WEST SUSSEX COUNTY COUNCIL CONSULTATION

TO:	Arun District Council FAO: Simon Davis
FROM:	WSCC - Highways Authority
DATE:	15 October 2019
LOCATION:	2 Cavendish Road, Bognor Regis, PO21 2JW
SUBJECT:	BR/256/19/PL Conversion of existing store to 3 No. bed dwelling including front single storey and roof dormer extension.
DATE OF SITE VISIT:	N/A
RECOMMENDATION:	Advice
S106 CONTRIBUTION TOTAL:	N/A

Proposed Ground Floor Plan

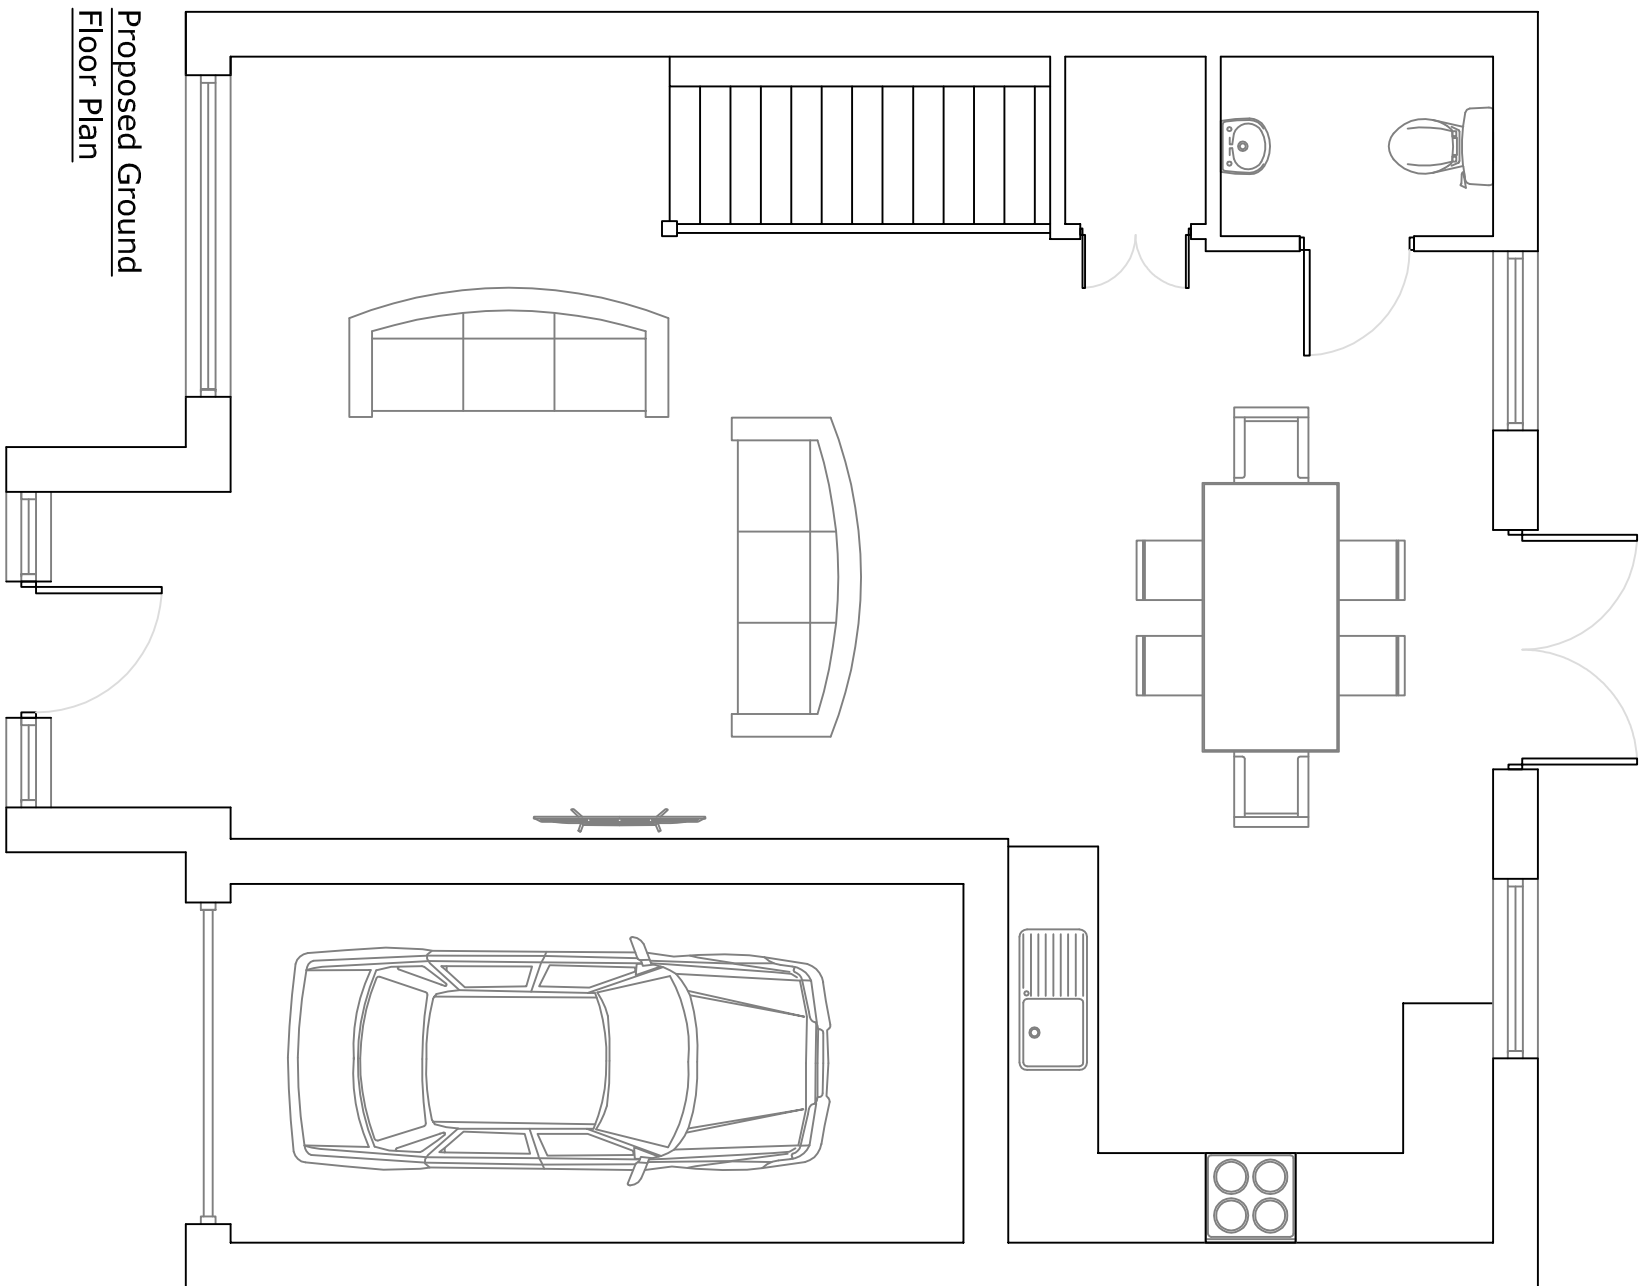
A single car garage is proposed for the dwelling. The garage demonstrated in the plans has approximate internal dimensions of 2.4m x 4.9m. This does not meet the minimum internal specifications for single car garages of 3m x 6m as set out in Manual for Streets (MfS). The applicant is therefore advised to modify the plans so that the garage meets the MfS minimum internal specification, so that it can be considered for parking provision.

The WSCC Car Parking Demand Calculator has indicated that a property of this size in this location would create a demand for 2 car parking spaces. Consequently, any overspill parking would have to be accommodated on-street. As the proposed garage does not meet MfS specifications, this application is being assessed based on a nil parking provision.

No cycle parking has been demonstrated in the plans. The applicant is advised to include secure and covered cycle parking in the plans to promote the use of sustainable alternative modes of transport to the private car.

No part of the development shall be first occupied until covered and secure cycle parking spaces have been provided in accordance with plans and details submitted to and approved by the Local Planning Authority.

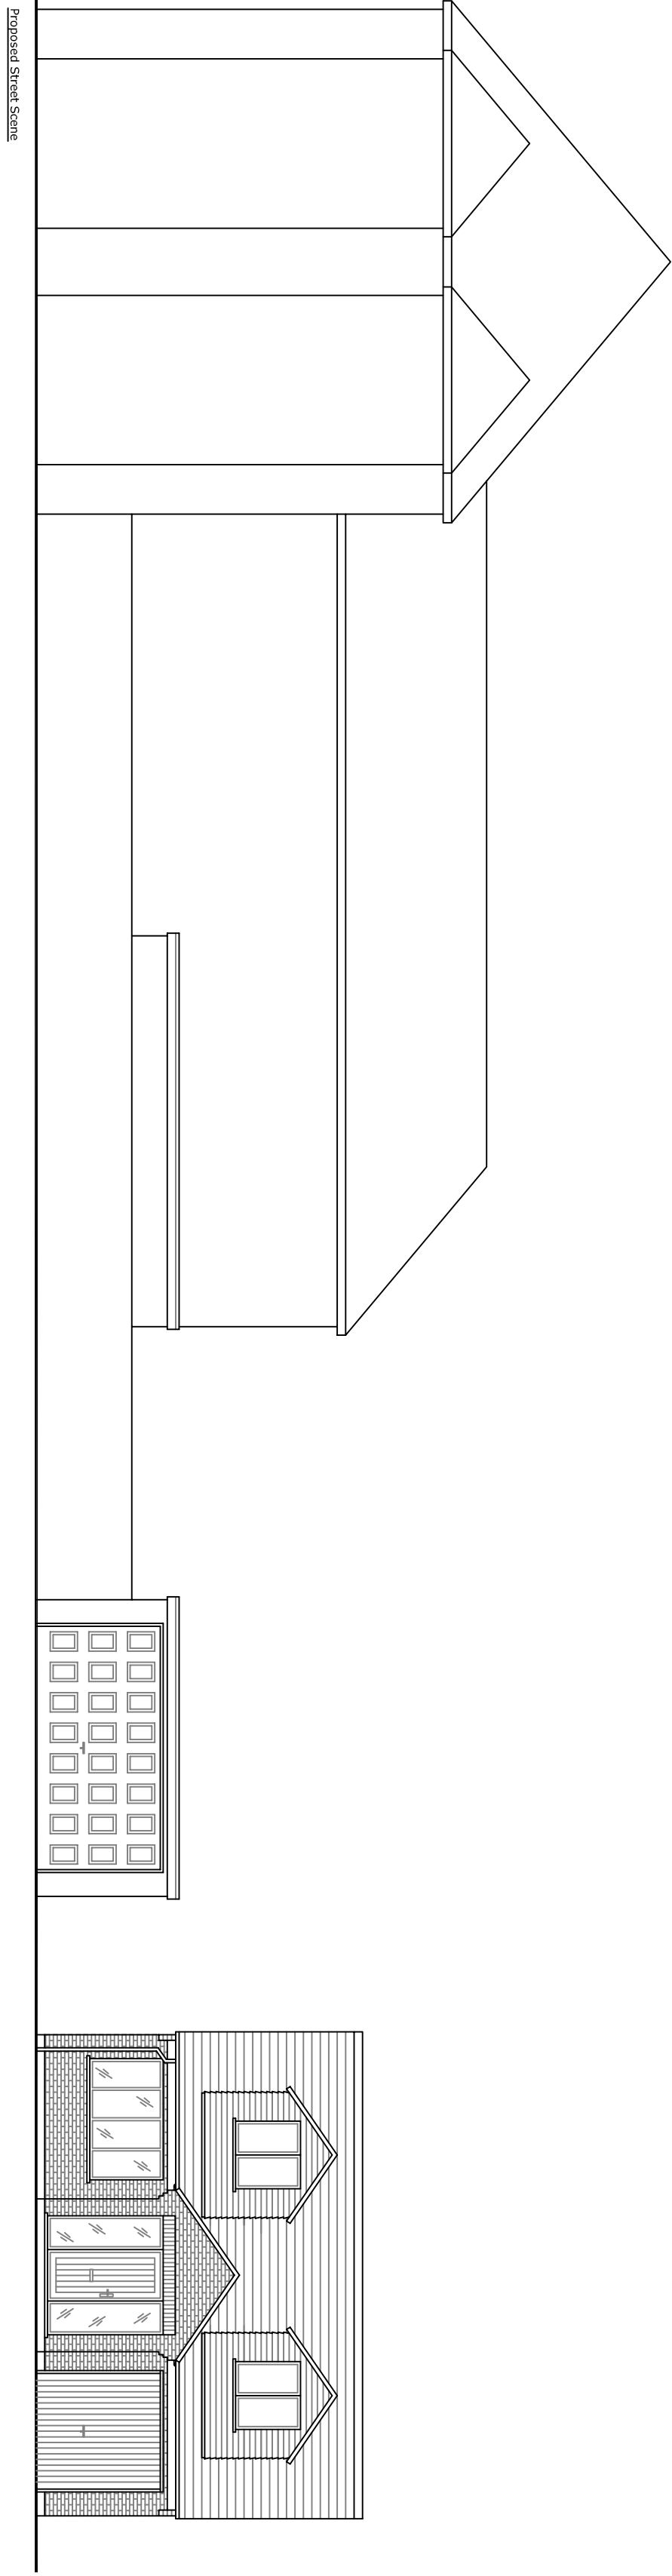
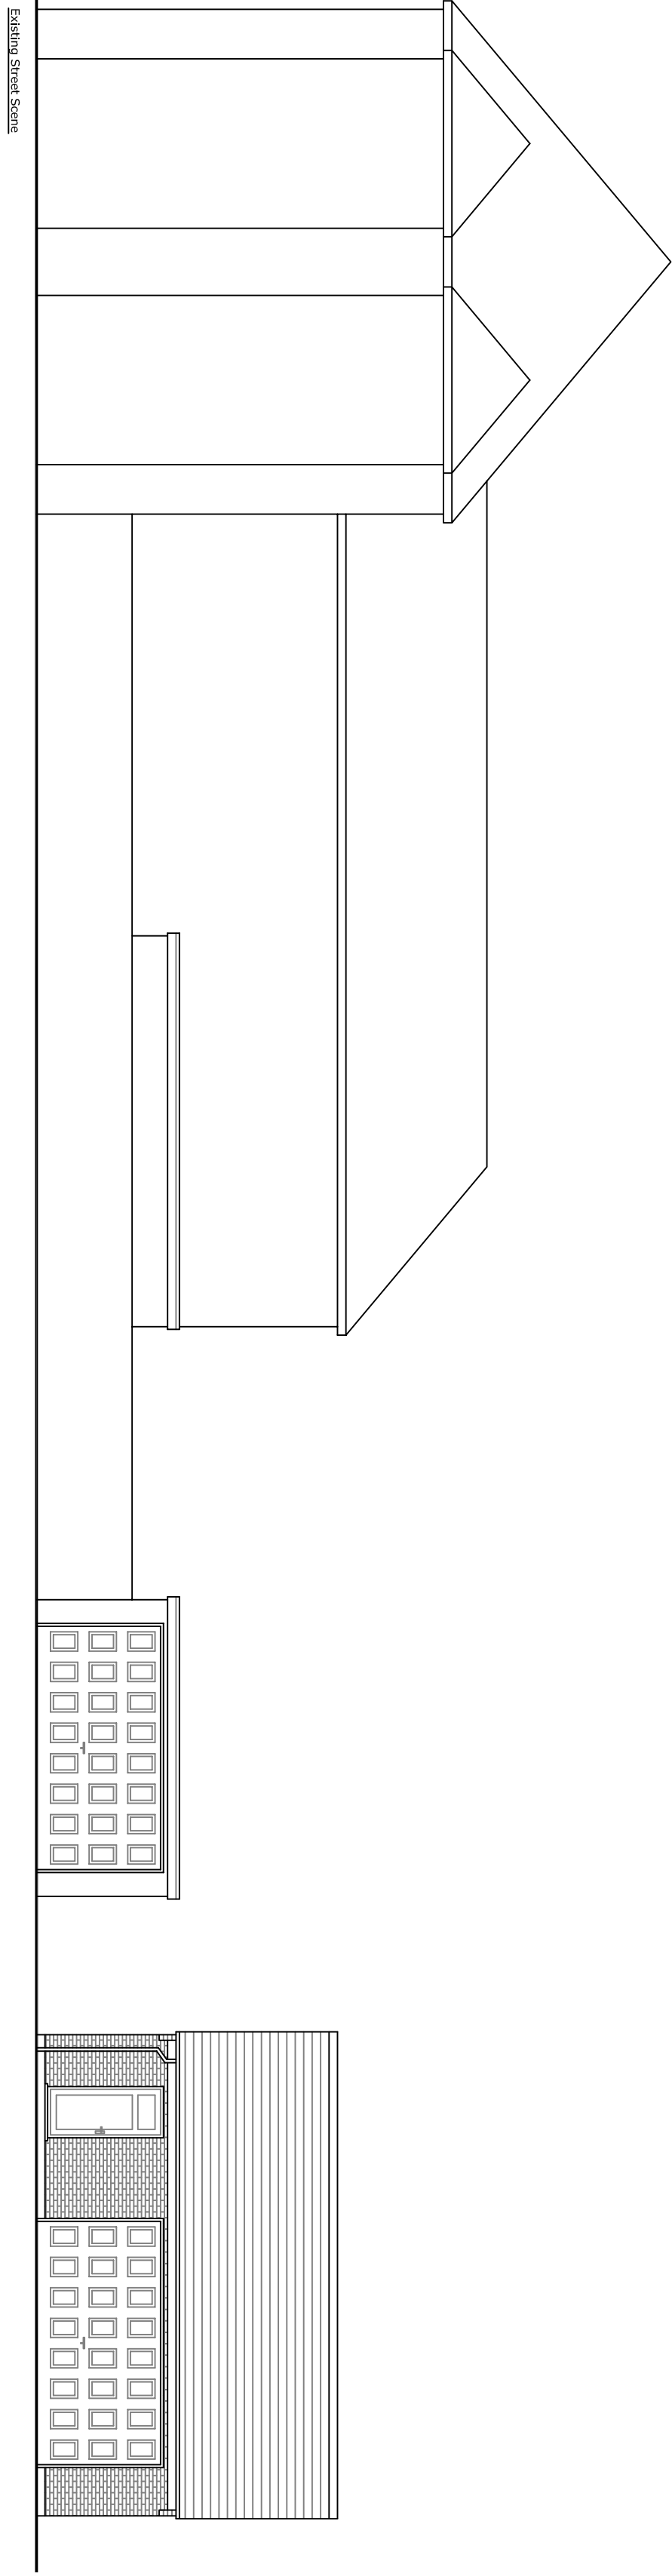
The existing access via Sutherland Close will be utilised. There is an existing dropped kerb to the front of the property. To avoid potential conflict with the kerb, the applicant is advised to have the existing dropped kerb widened. This would be subject to a licence and would be constructed to a specification agreed with the local area engineer.
